**Fire Suppression System Permit Application 2017-00019 - 1 Thompson's Point**4 messages

RE: Fire Suppression System Permit Application 2017-00019 - CBL: 201 A005001  
1 Thompson's Point

DRAWING NO.:
FP-01 REVISED

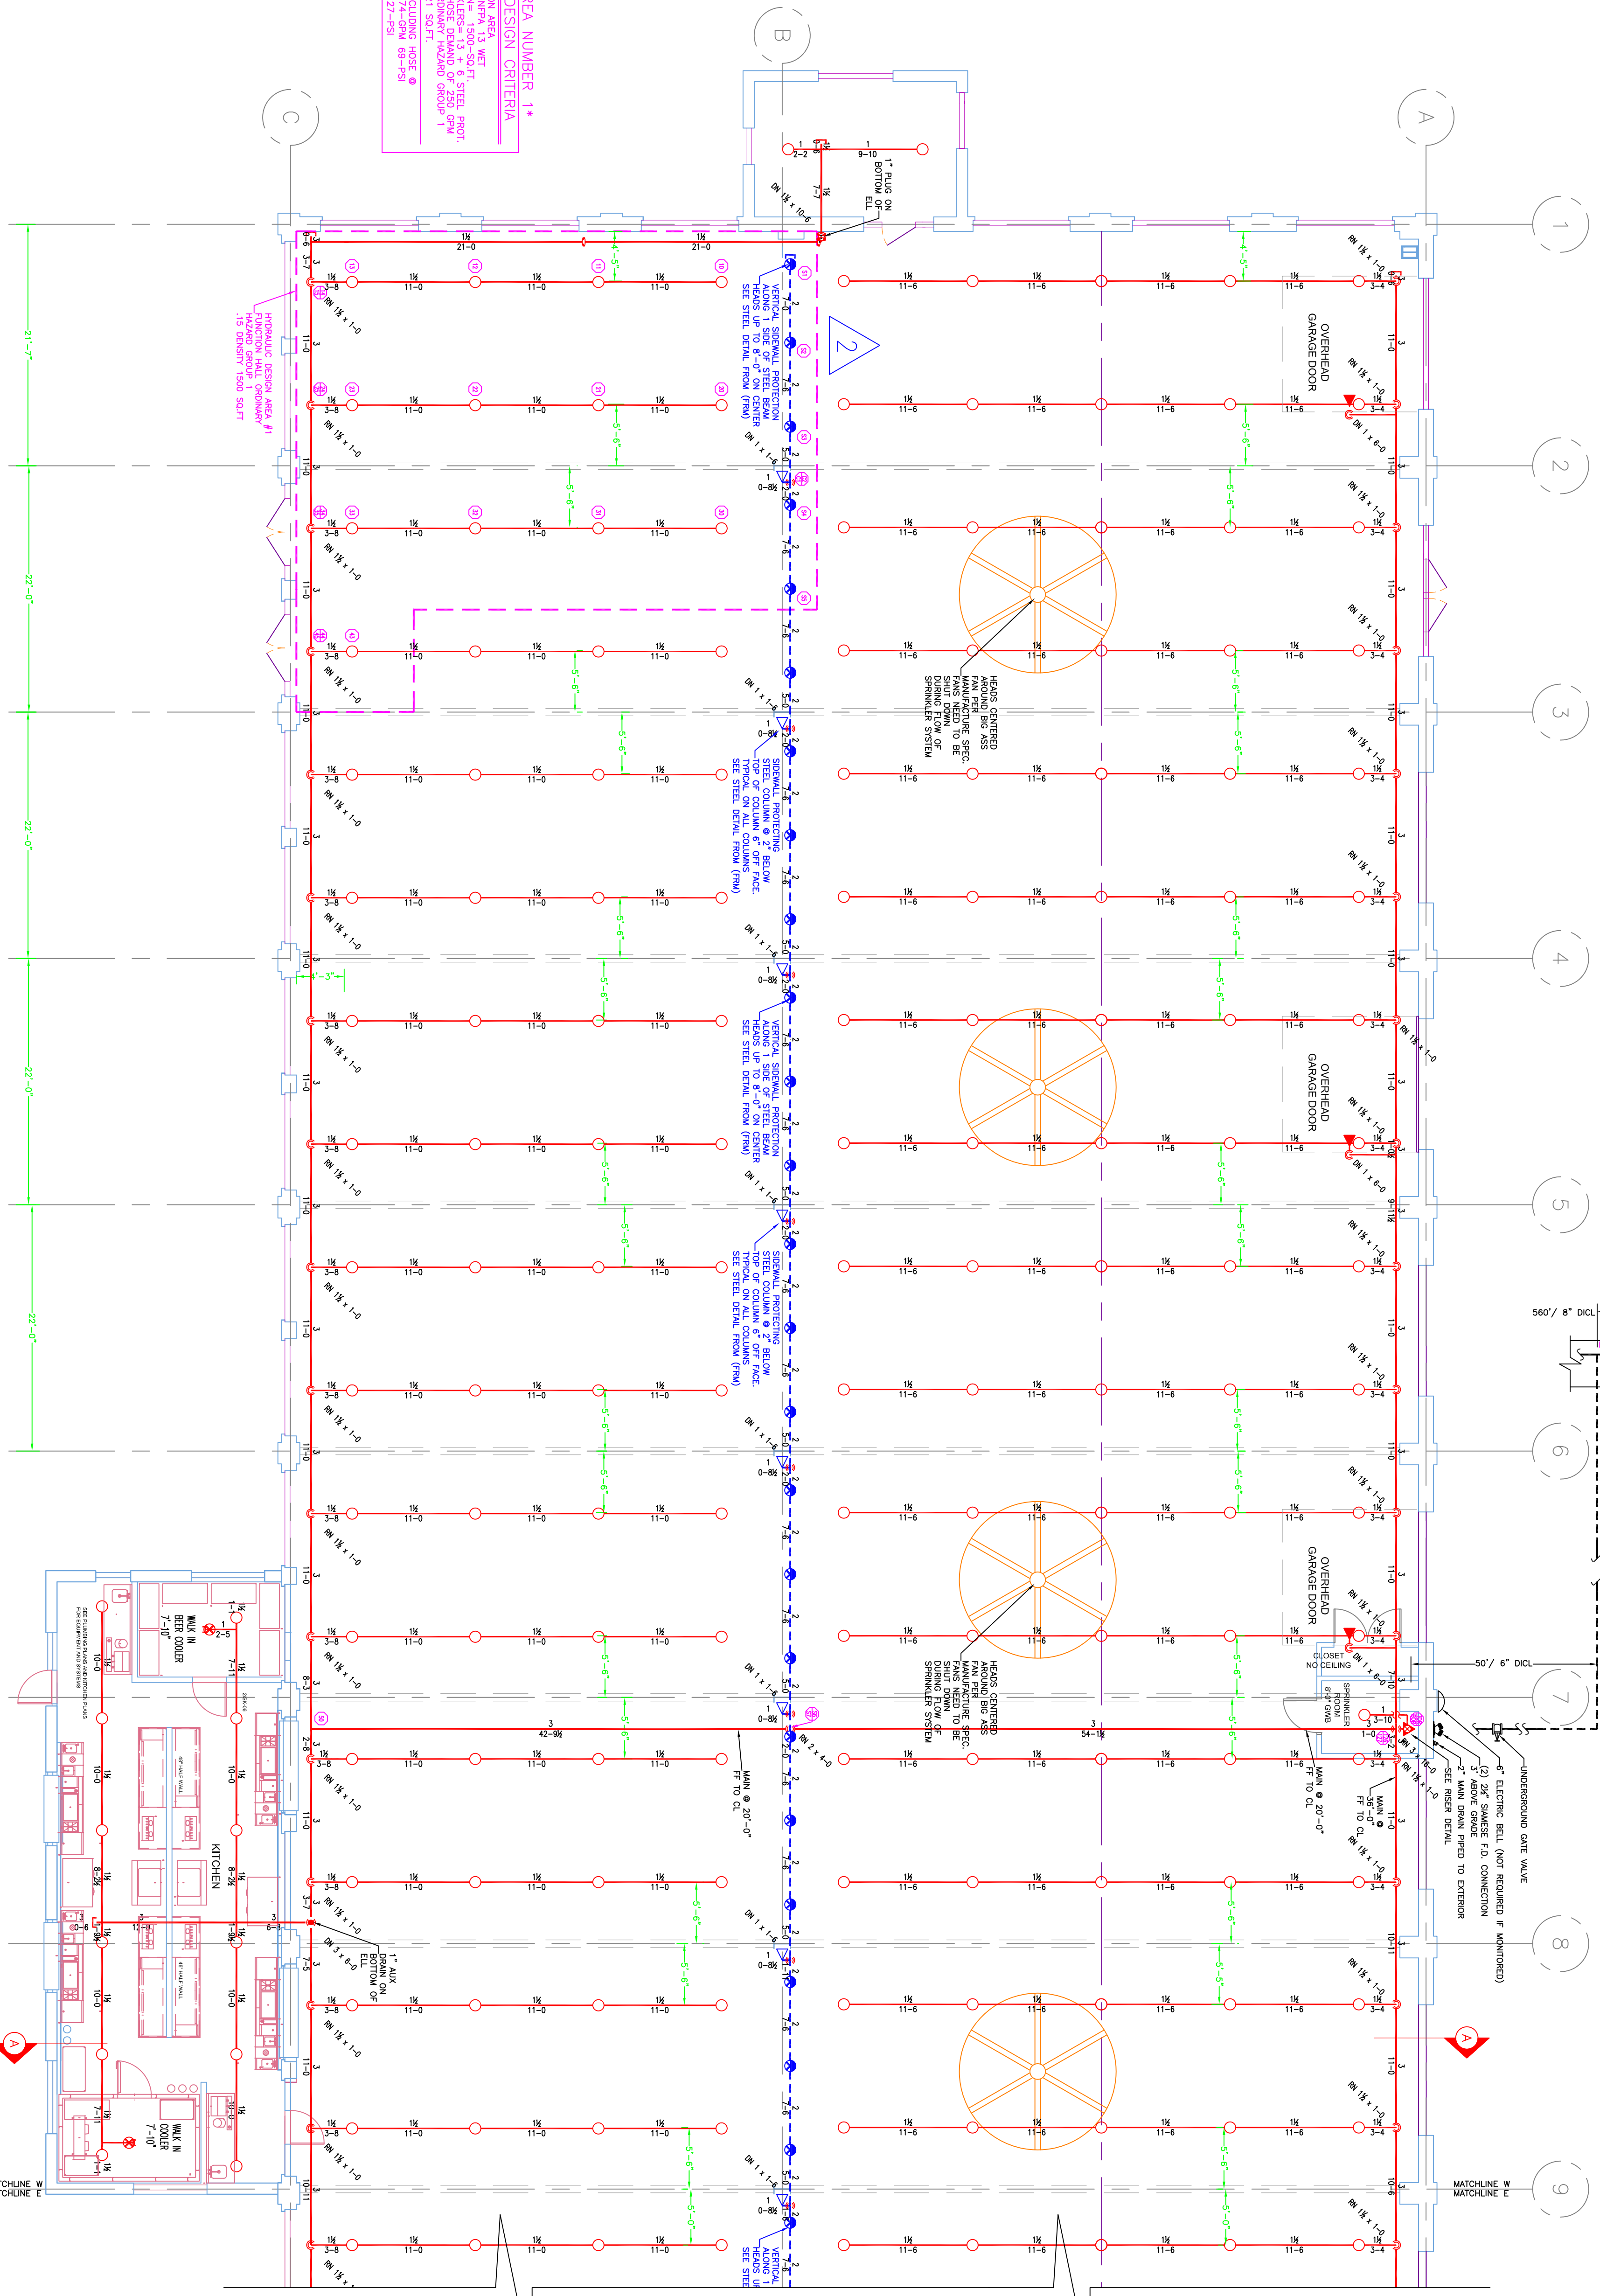
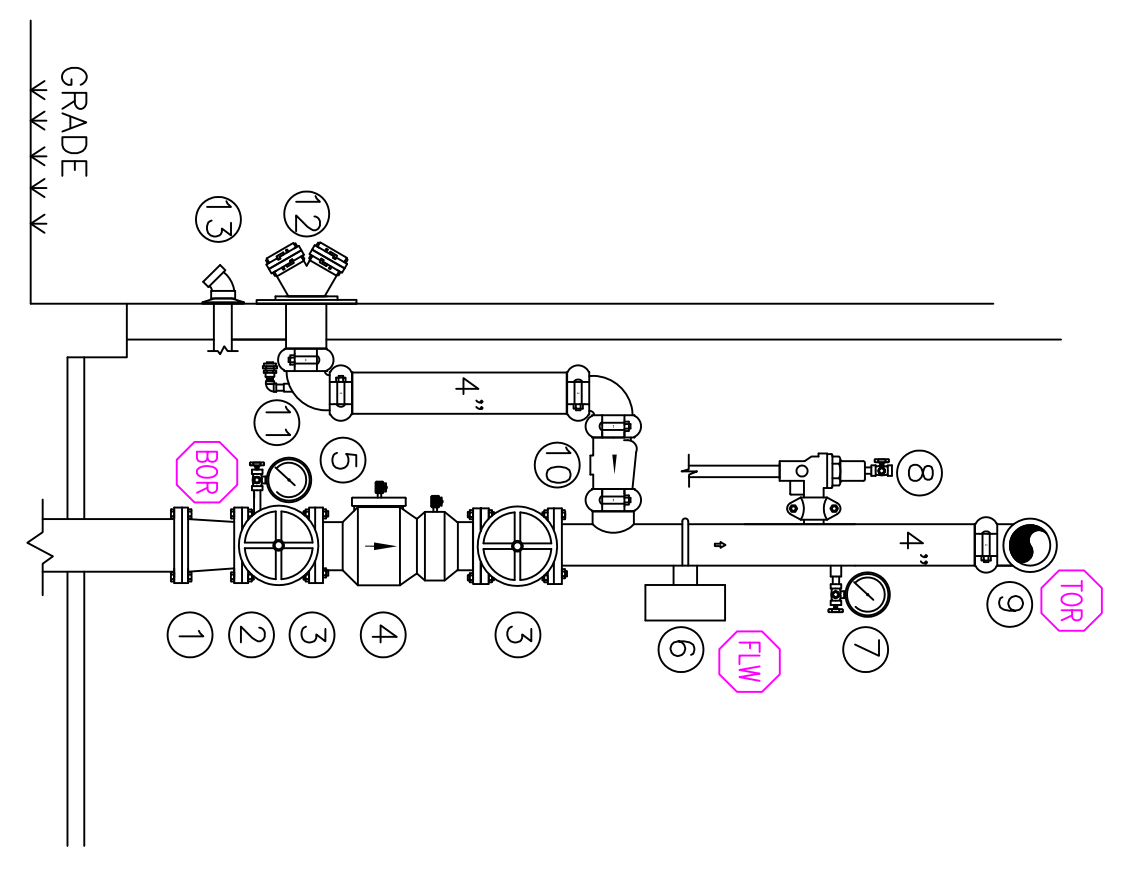
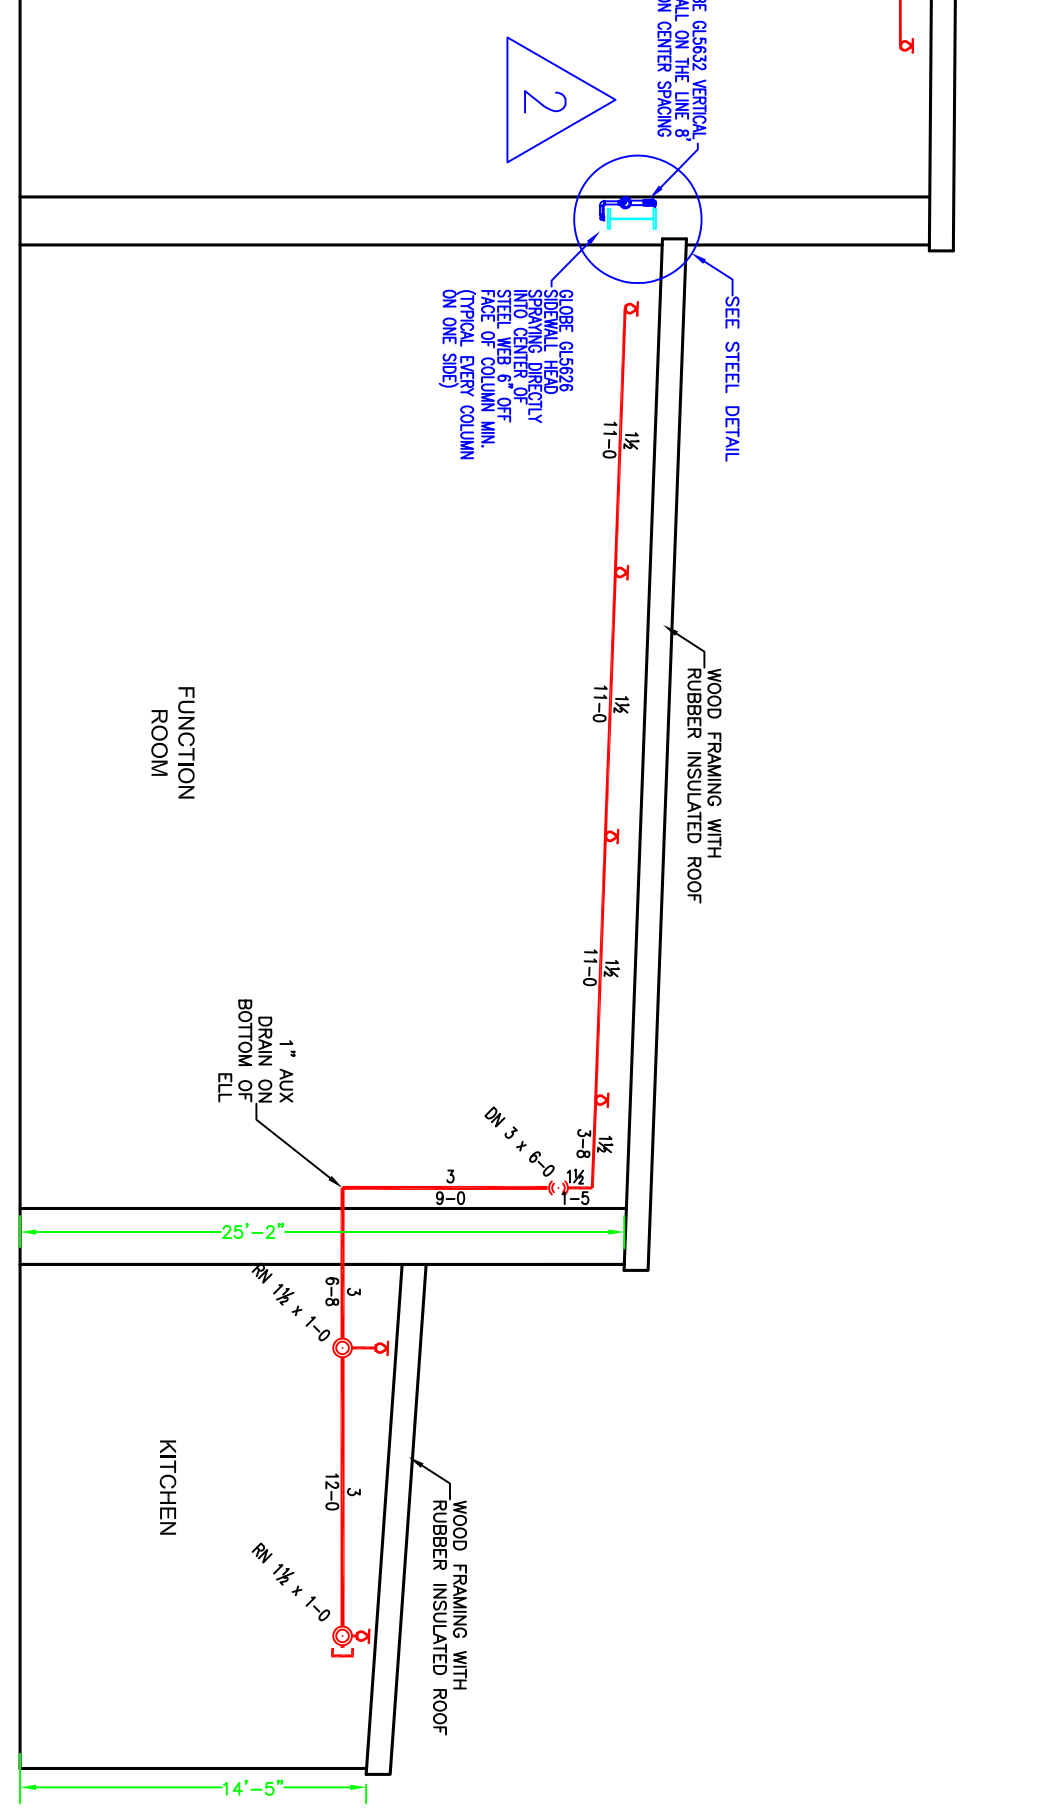
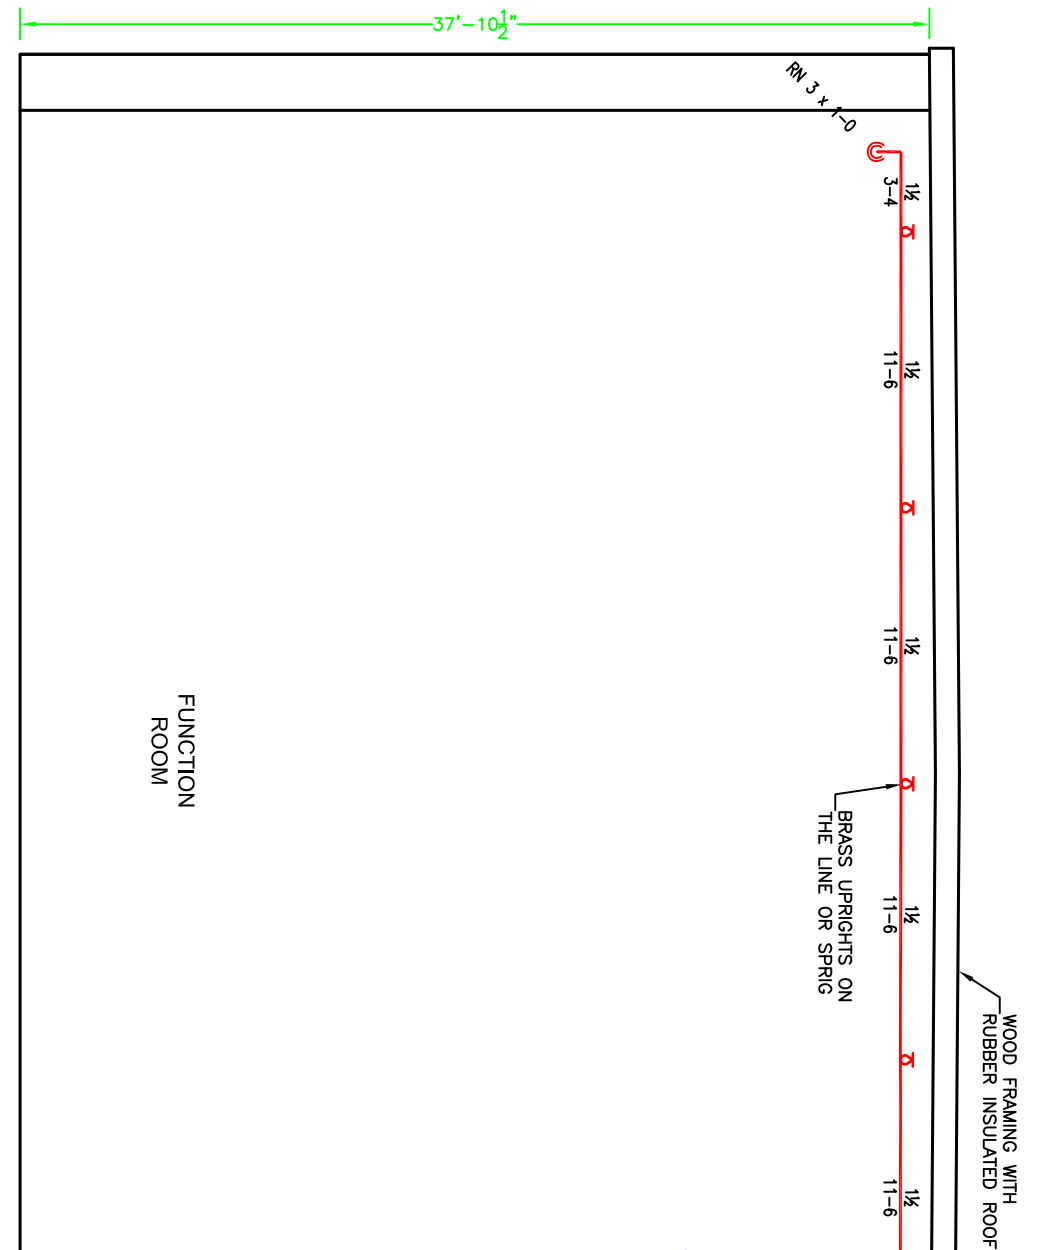
One pair of drawings called for protection of the vertical columns by the sprinkler system, the second pair of drawings did not have that protection.

Also, there was a question as to whether it is necessary to have thermal, and intumescent protection of the steel components.

Attached are the most current sprinkler drawing for the Brick South Building on 1 Thompsons Point.

These drawing show the steel beams in the building being protected via the fire sprinkler system feed.

The state fire marshal's office has these same drawings and has approved this design as adequate.
